KITTITAS COUNTY COMMUNITY DEVELOPMENT SERVICES

June 28, 2010

RE: Ridgway Short Plat (SP-07-00039)

The Kittitas County Community Development Services Department has determined that the Ridgway Short Plat (SP-07-00039) is a complete application and hereby grants *conditional preliminary approval* subject to the following conditions:

RIDGWAY SHORT PLAT

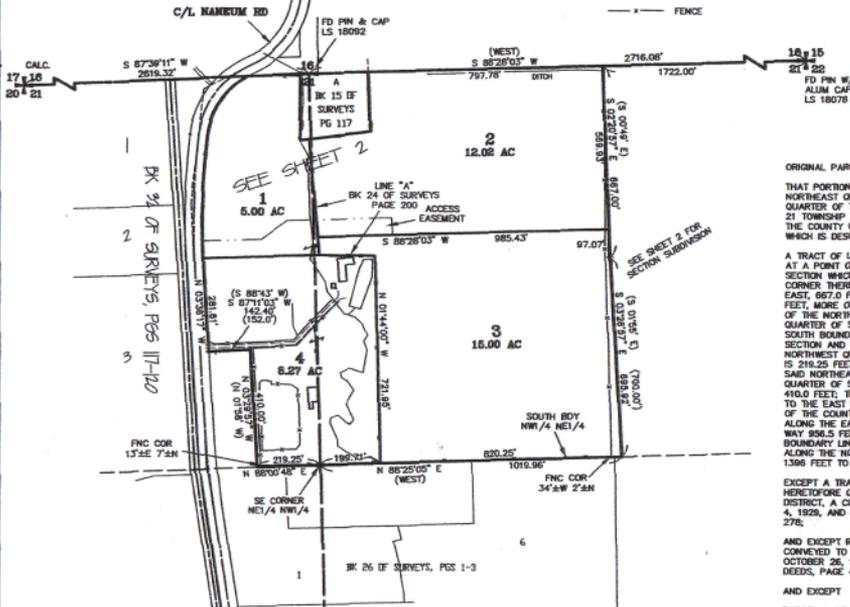
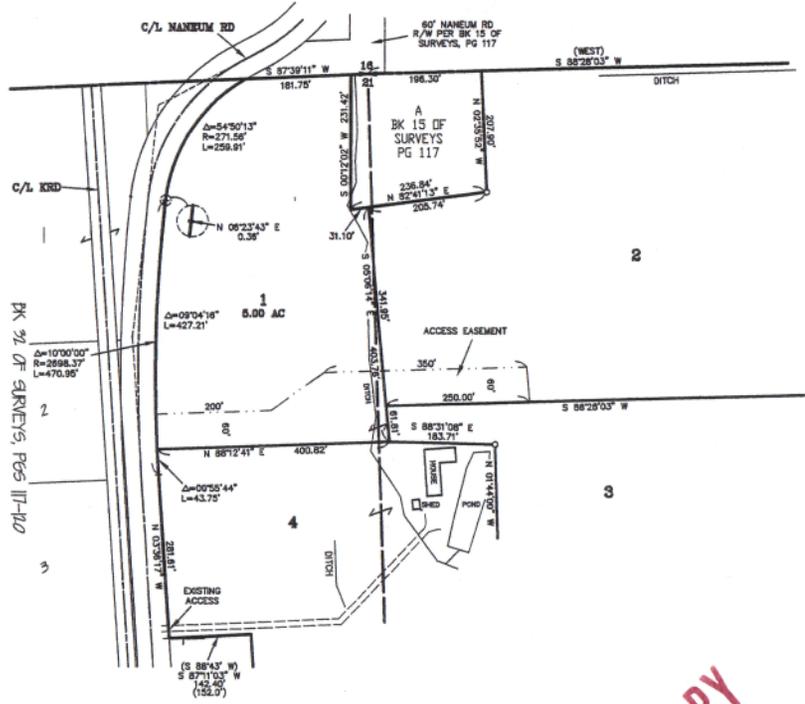
1. Both sheets of the final mylars shall reflect short plat number SP-07-00039 and an accurate legal description shall be shown on the face of the final plat.

2. Full year's taxes must be paid on all tax parcel numbers per requirement of the Kittitas County Treasurer's Office.
3. The following plat notes shall be recorded on the final mylar drawings:

- All development must comply with International Fire Code.
 - This short plat has exhausted the use of the one time split provision allowed per Kittitas County Code. No further one time splits are allowed for the subject parcels and subsequent parcels created via this short plat.

- The subject property is within or near designated natural resource land of long-term commercial significance on which a variety of commercial activities may occur that are not compatible with residential development for certain periods of limited duration. (RCW 36.70A.060(1)) Commercial natural resource activities performed in accordance with county, state and federal laws are not subject to legal action as public nuisances. (RCW 7.48.305)

- Kittitas County relies on its record that a supply of potable water exists. The approval of this division of land includes no guarantee or assurance that there is a legal right to withdraw groundwater within the land division.

- Metering shall be required on all new residential well connections and metering results shall be recorded in a manner consistent with Kittitas County and Washington State Department of Ecology requirements.

- Kittitas County will not accept private roads for maintenance as public streets or roads until such streets or roads are brought into conformance with current County Road Standards. This requirement will include the hard surface paving of any street or road surfaced originally with gravel.
